Your Ref: OWPC13888
Our Ref: R/64/17/PL 17-03-2017
Please ask for:
Mr D Easton

Demolition of 1 No. dwelling & erection of 4 No. dwellings. This application affects the character & appearance of the Station Road, East Preston Conservation Area.

St. Marys Close Hurst Road Rustington

Thank you for your internet representation made on 4th May 2017 which has been recorded as '**an objection**' with the comments as follows:

Drg No: 151117_SS-01 Rev: D

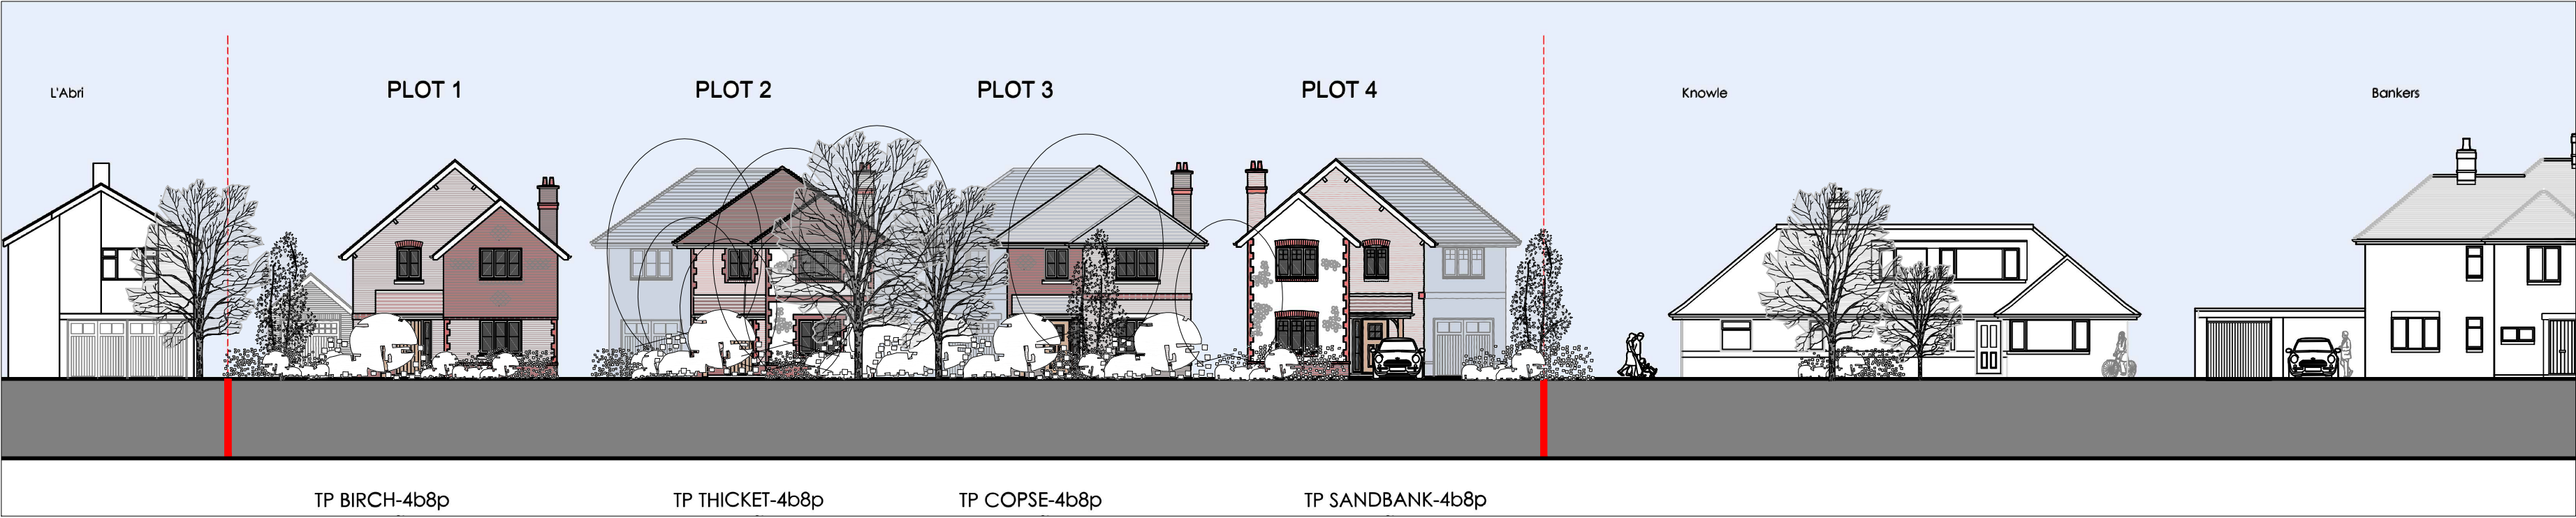
The proposed development will create a dense and modern mini estate in a road that currently has the characteristic of a spacious road with individual style houses, and will seriously effect the Street Scene in the eastern part of the road.

The four house development will be made up of two house designs unlike the individual houses of character that exist already in Hurst Road. It is unclear what the materials and colour is of roofs on the new houses will be.

The proposed positions of 2 detached garage blocks are in front of the building line. The easterly block approaches to within 8.5 meters of the road.
